Appendix D

Detailed Response to Submissions

1.1 Department of Planning, Housing and Infrastructure

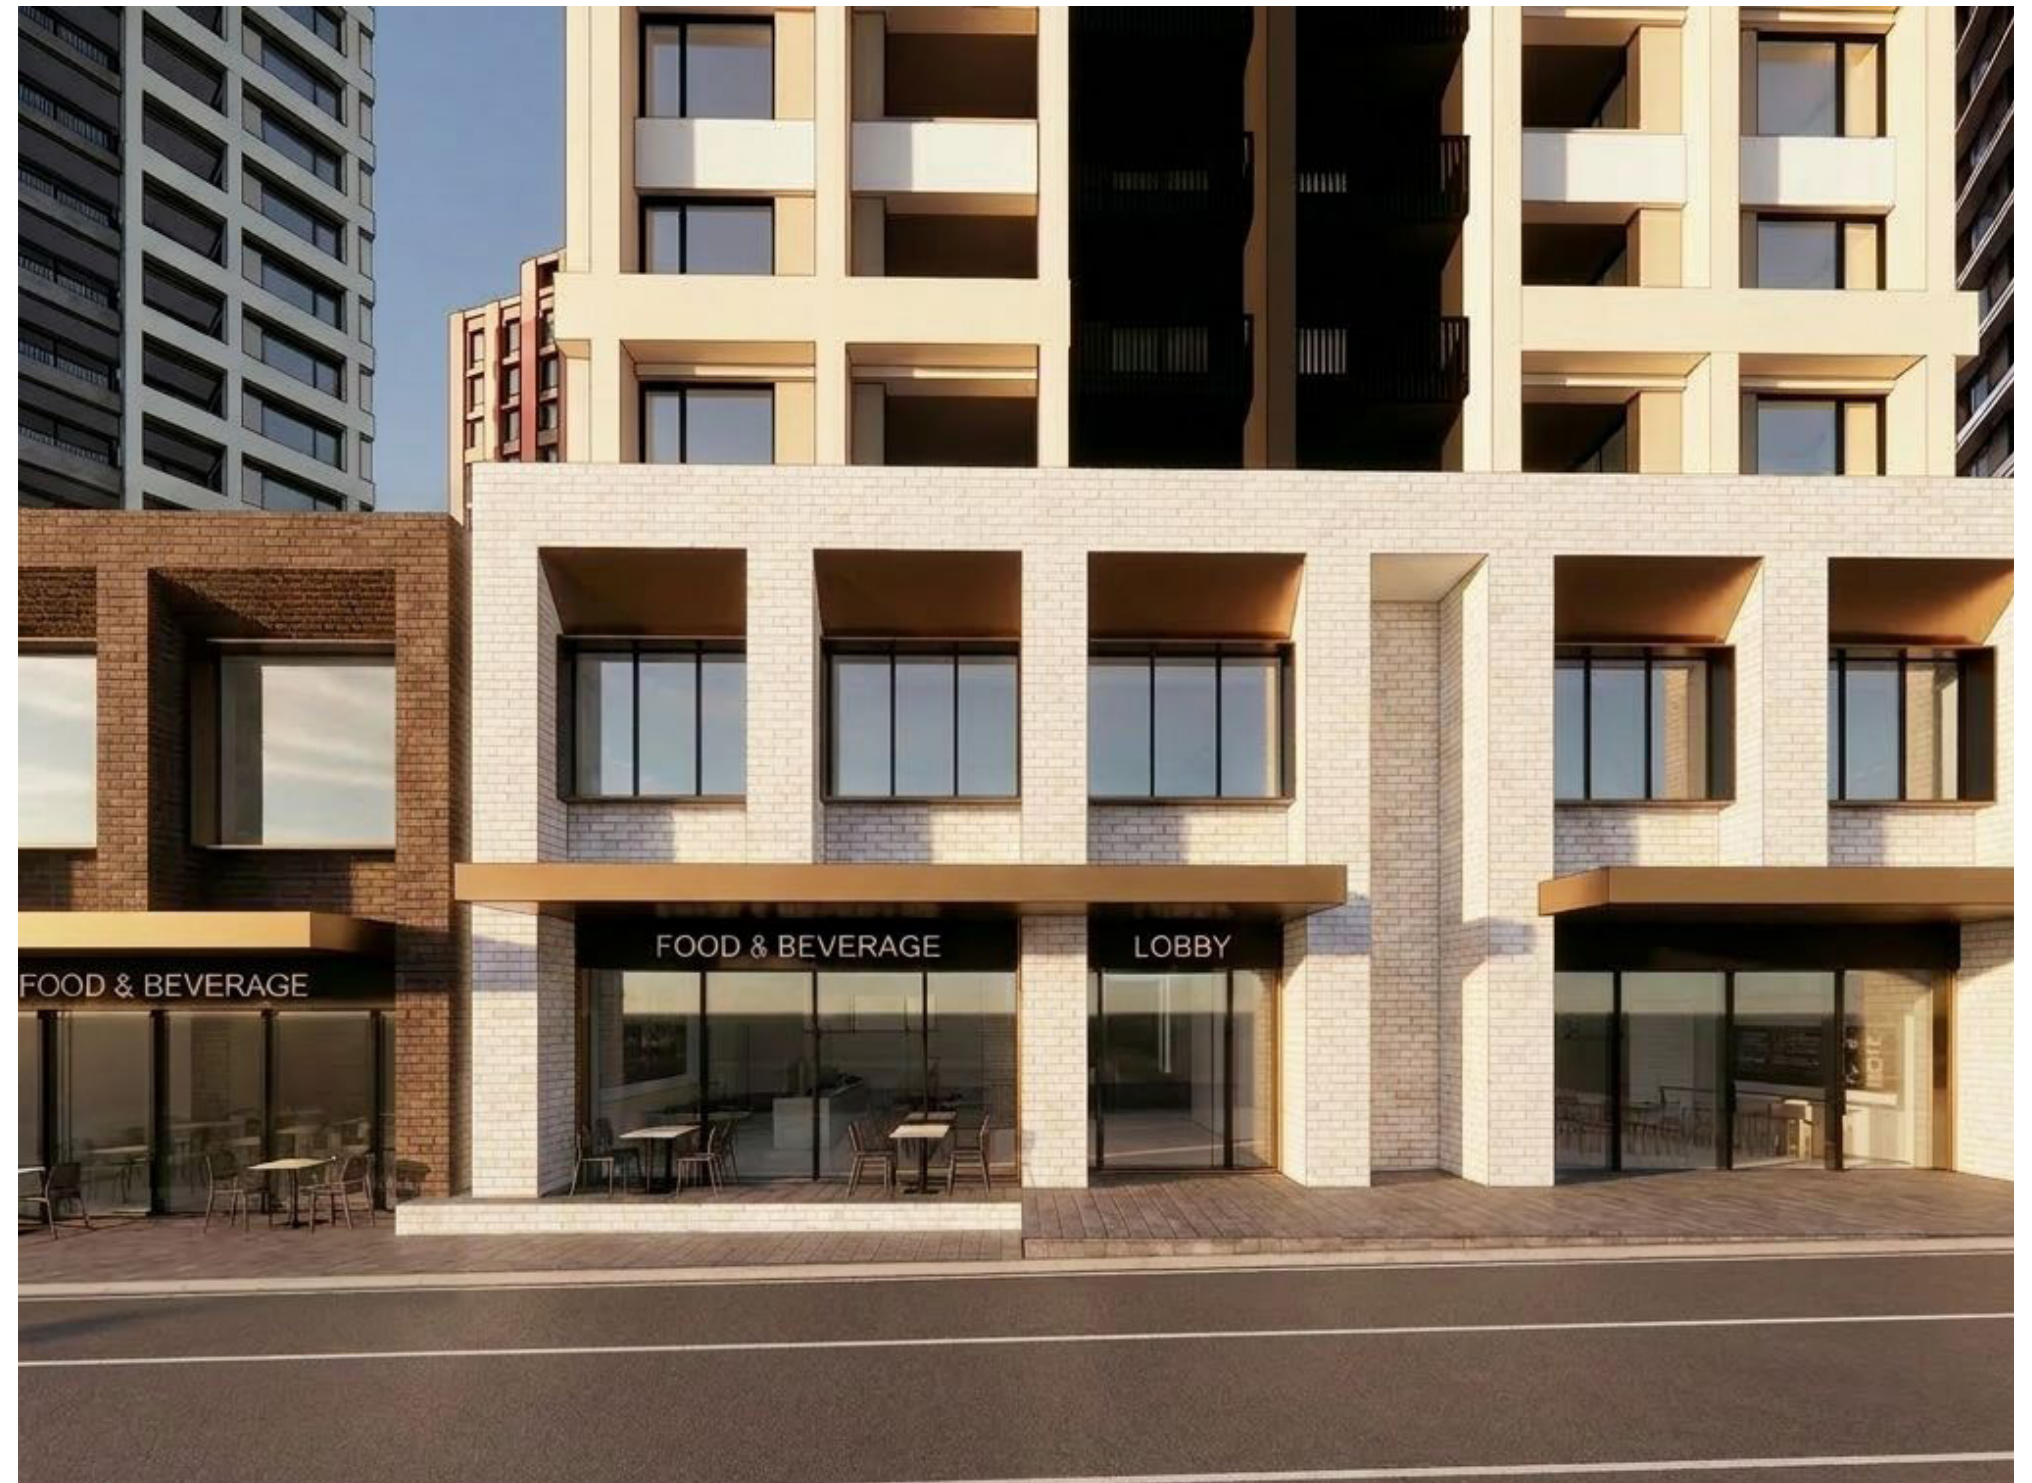
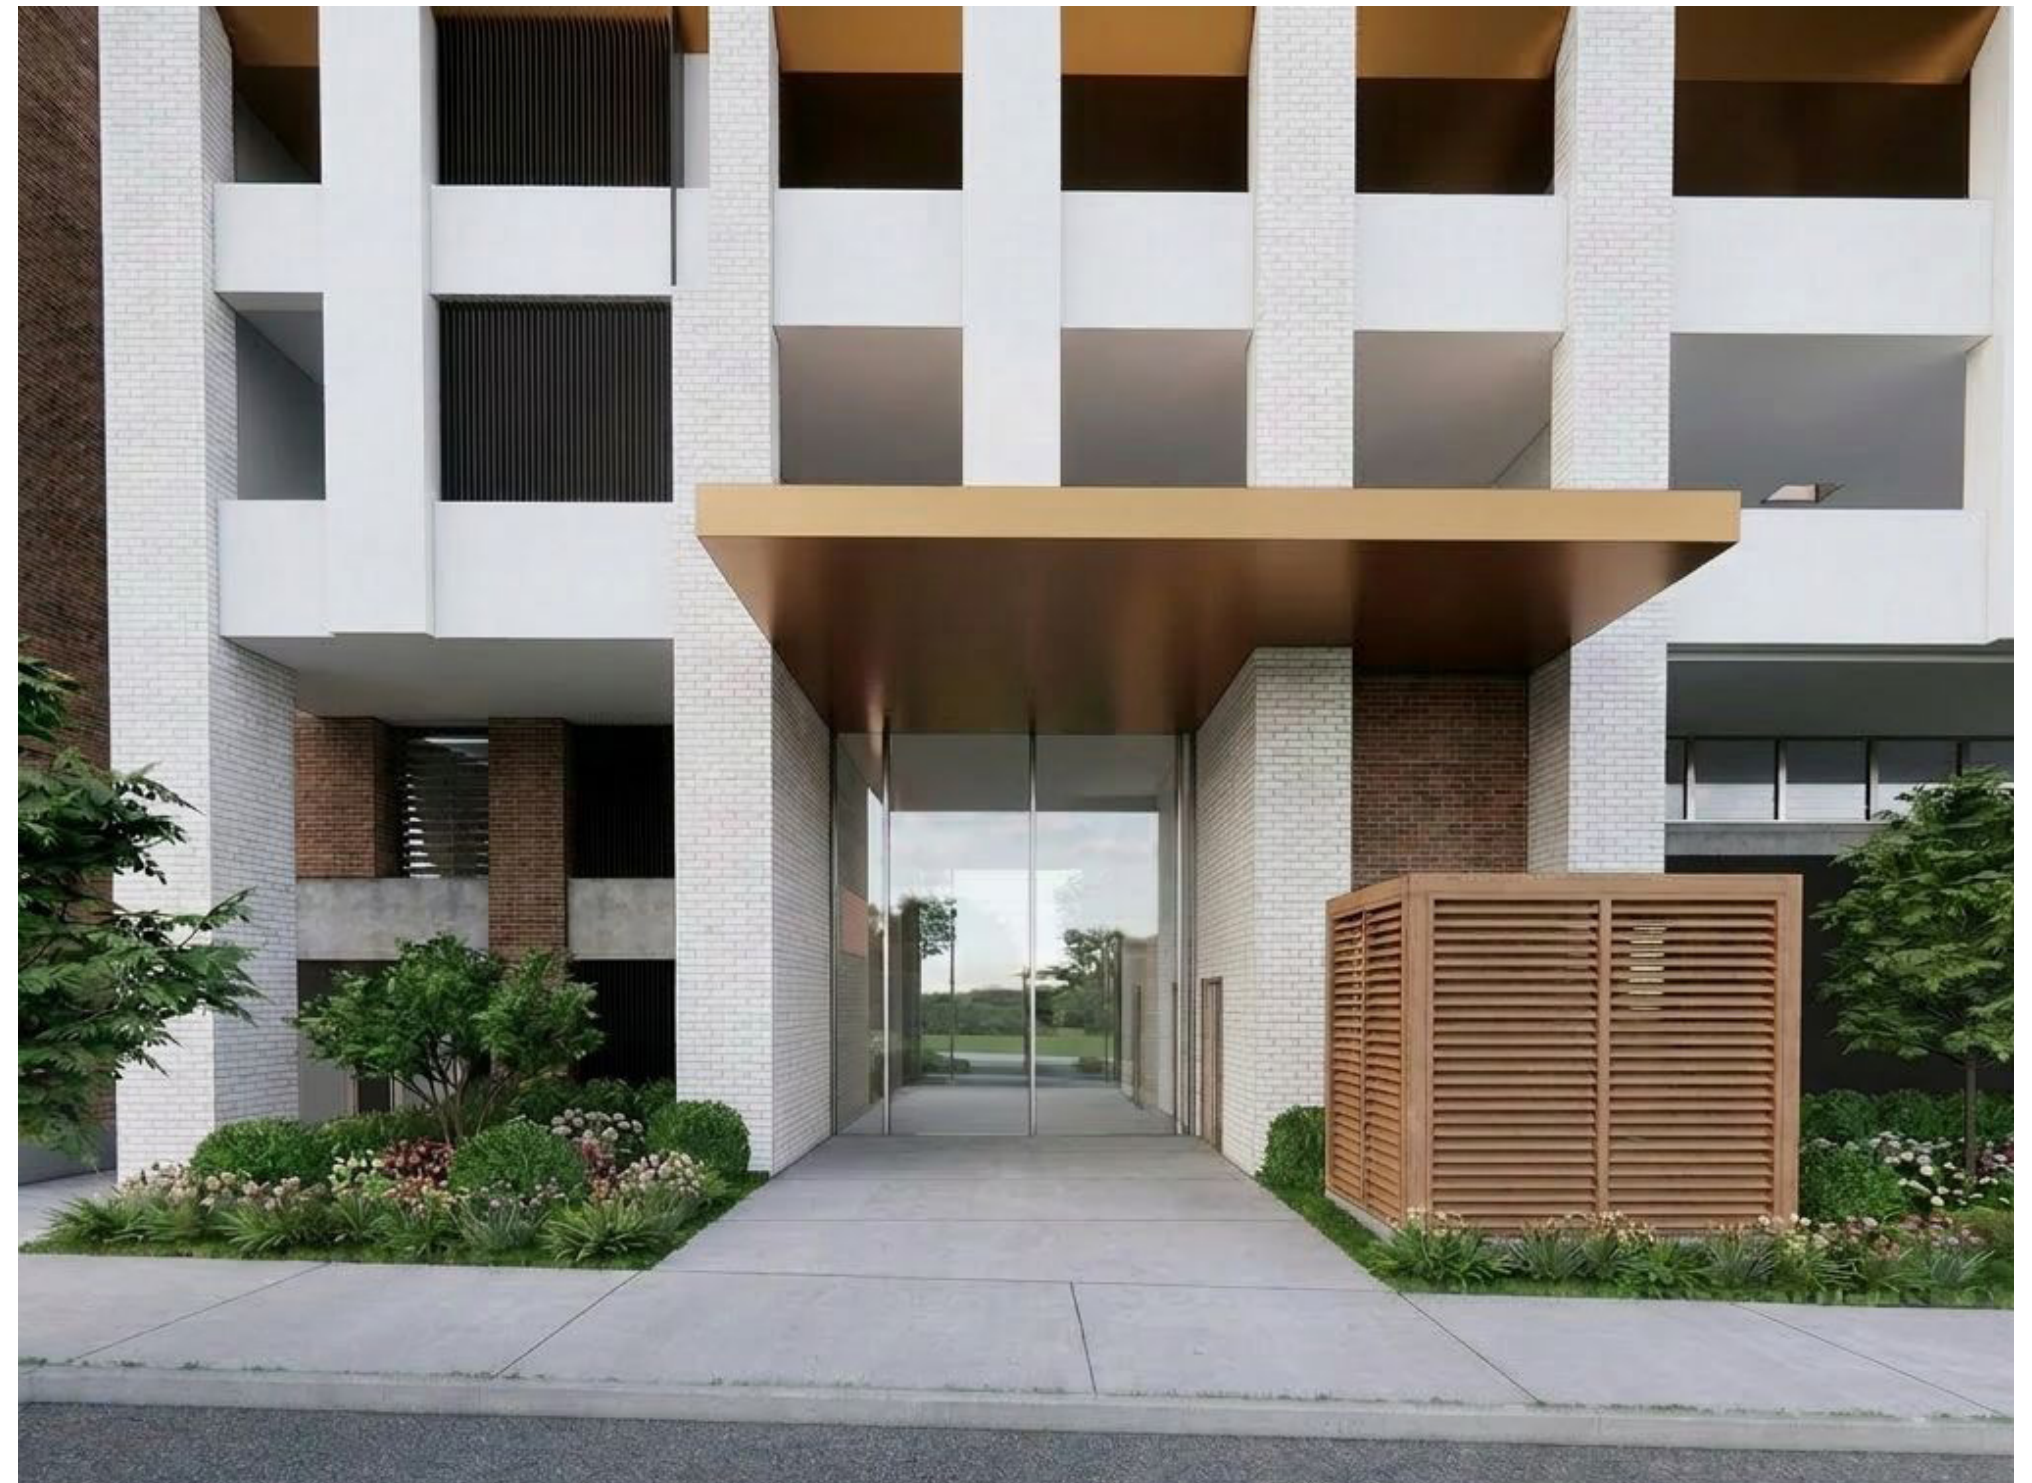
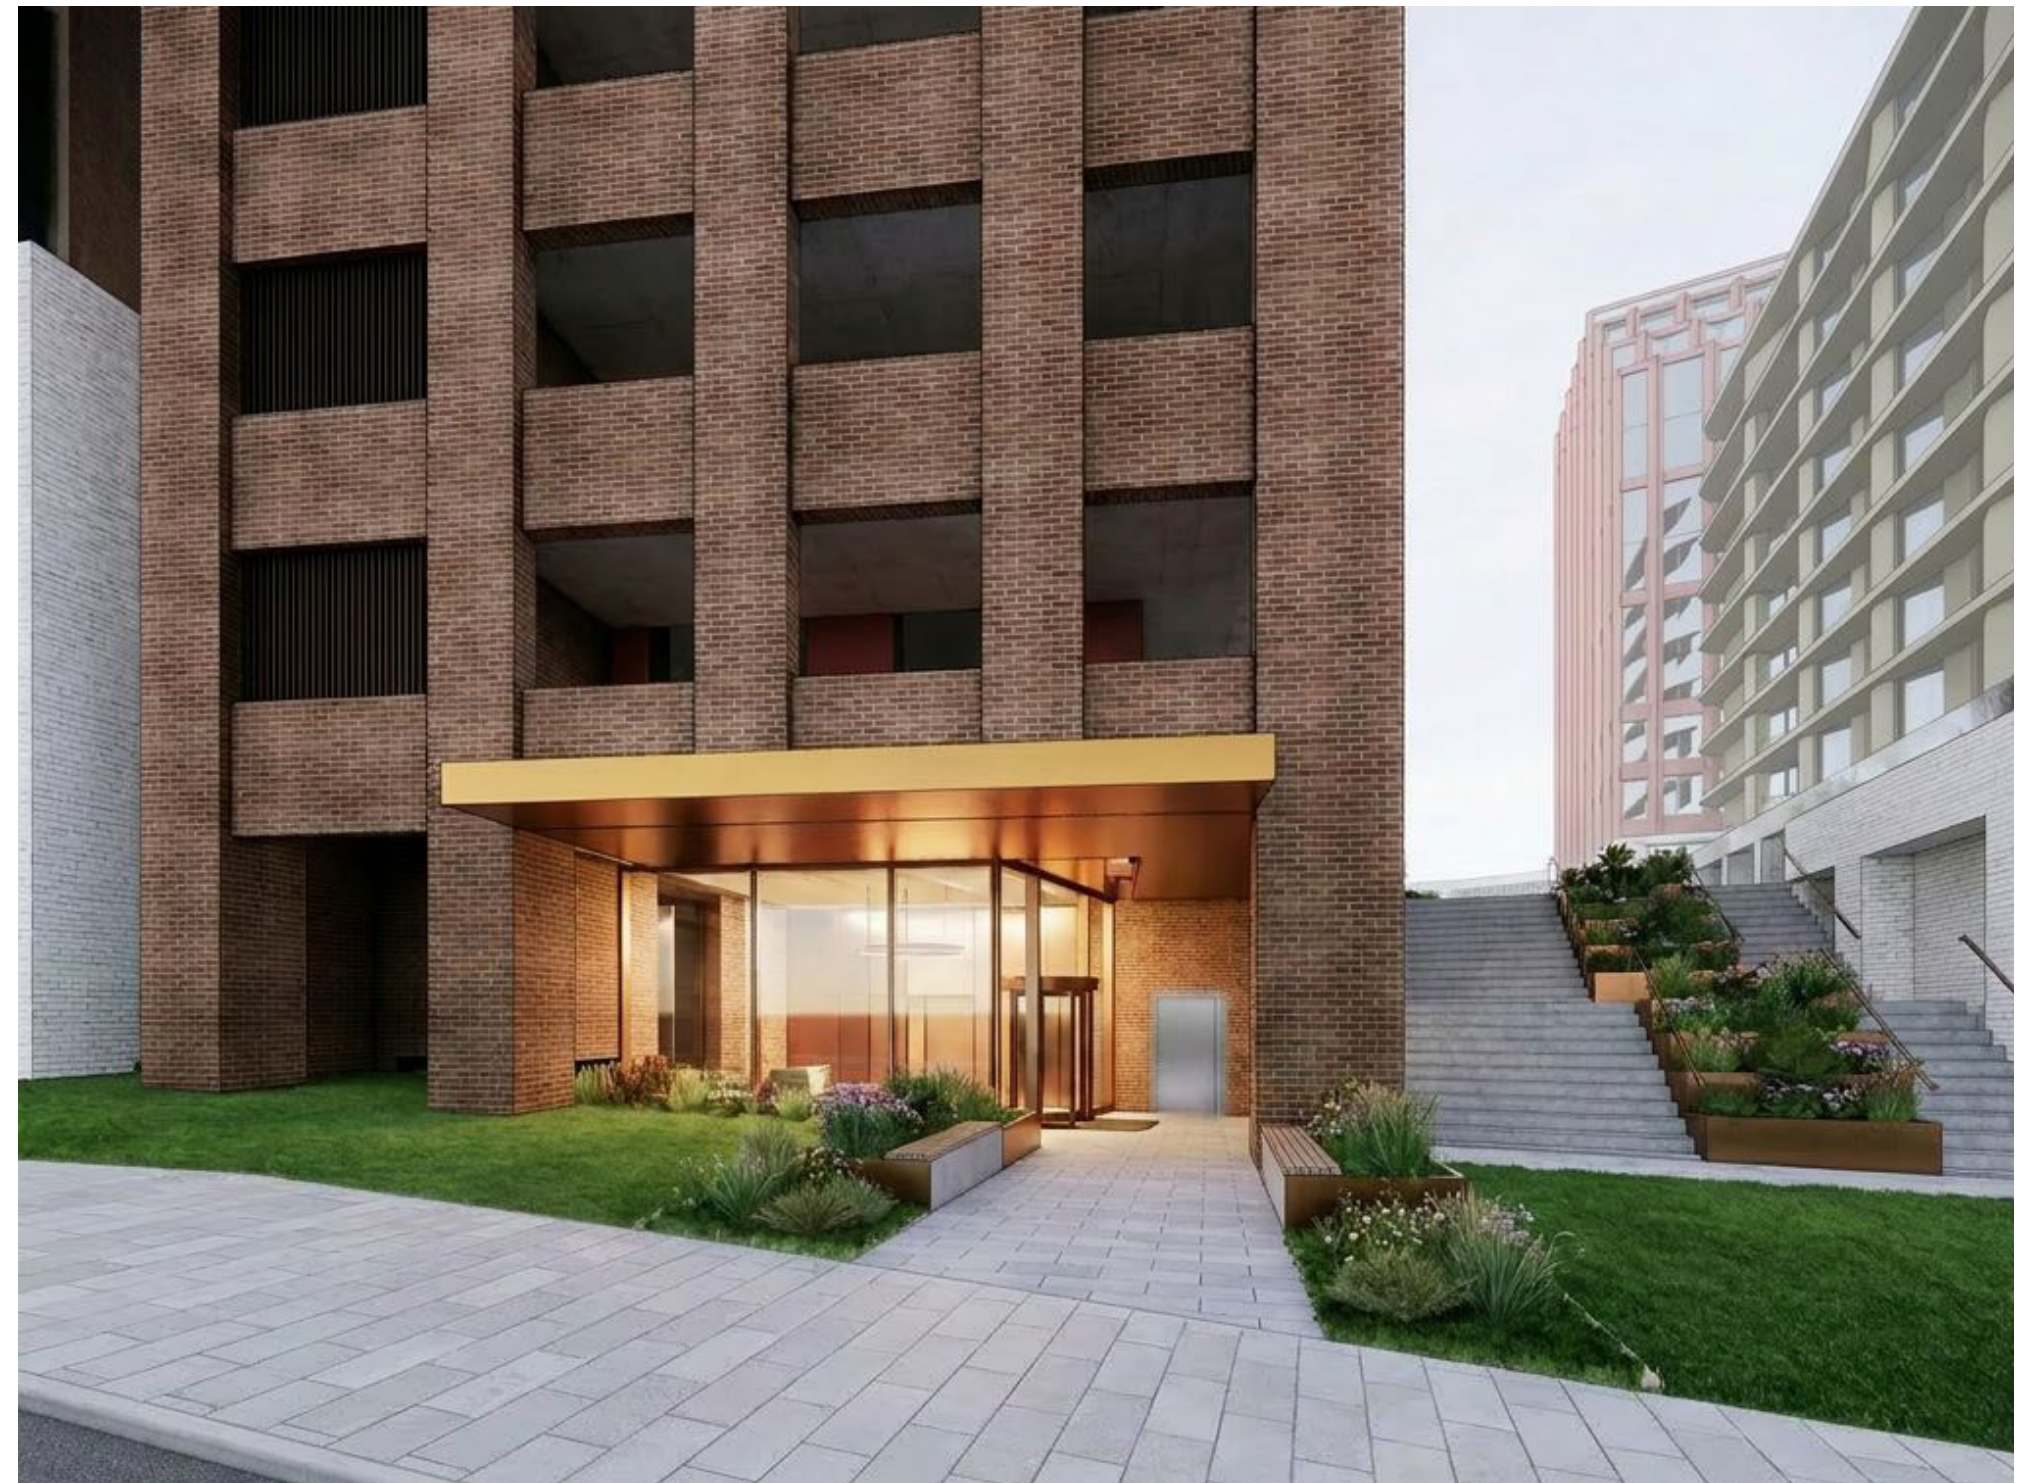
DPHI-36	<i>Update the architectural plans to detail doors or an appropriate entryway for each retail tenancy.</i>	The Updated Architectural Drawings (Drawings 2001, 2002, 2003, 2004, and 2005) at Appendix E , provides details of the entryway to each retail tenancy.
DPHI-37	<i>Provide detailed elevations and renders of entries into each residential lobby on the site.</i>	The Updated Design Report at Appendix F provides renders of the entrance to each residential lobby on the site.
Submission #2		
Waste		
DPHI-38	<i>Show a dedicated waste room for the commercial building on the plans.</i>	Refer to Appendix A.1 of the Updated OWMP at Appendix W for labelled bin rooms and their specific locations. The dedicated commercial bin room is located on the mezzanine level.
DPHI-39	<i>Further assess waste collection requirements for the supermarket and detail a waste storage area of sufficient size on the plans.</i>	Not applicable as the proposed development no longer includes a supermarket tenancy,
